From: Susan Haley
Sent: 06 February 2026 15:59
To: [REDACTED]
Subject: RE: R/6/26/CLP - 15 Evelyn Avenue, Rustington

I have begun looking at application R/6/26/CLP - 15 Evelyn Avenue, Rustington and wished to inform you we have amended the description to the following – a ‘Lawful development certificate for proposed hip to gable extensions, rear dormer, roof lights, and side windows’, to simplify it.

Rev	Notes	Date
 M: 07599199759 E: info@nat-design.co.uk www.nat-design.co.uk		
Project:		
15 Camelia Close, Littlehampton, BN17 6UT		
Drawing:		
Proposed Elevations		
Drawn by NSE	Scale as shown	
Date Nov 2025	Revision	
Drawing		
2015 - DPA - 06

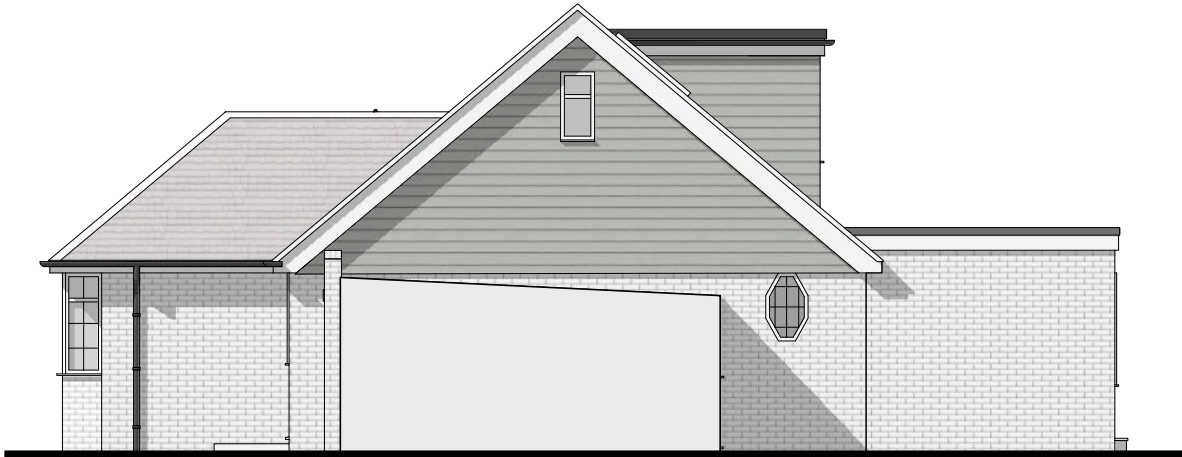
Based on the information within your reply, it is highly likely the certificate would be refused, as the cladding proposed is not located on the exterior of the existing property, as per A.3 of Schedule 2, Part 1, Class A (The Town and Country Planning (General Permitted Development) (England) Order 2015)— (a)the materials used in any exterior work (other than materials used in the construction of a conservatory) must be of a similar appearance to those used in the construction of the exterior of the existing dwellinghouse.

As you mentioned the client would be happy to amend the material to tile hanging on the dormer and gable ends, which would be acceptable for permitted development purposes. Therefore, please can you amend the plans accordingly and email me so they can be uploaded.

I also noted that the proposed elevation plan (2015-DPA-06) shows cladding on the rear dormer and gable ends. Please can you confirm that the dwelling currently has cladding and state its location on the original dwelling.

Thank you for clarifying this. The client is happy to use tile hanging so please find attached an updated drawing showing this.
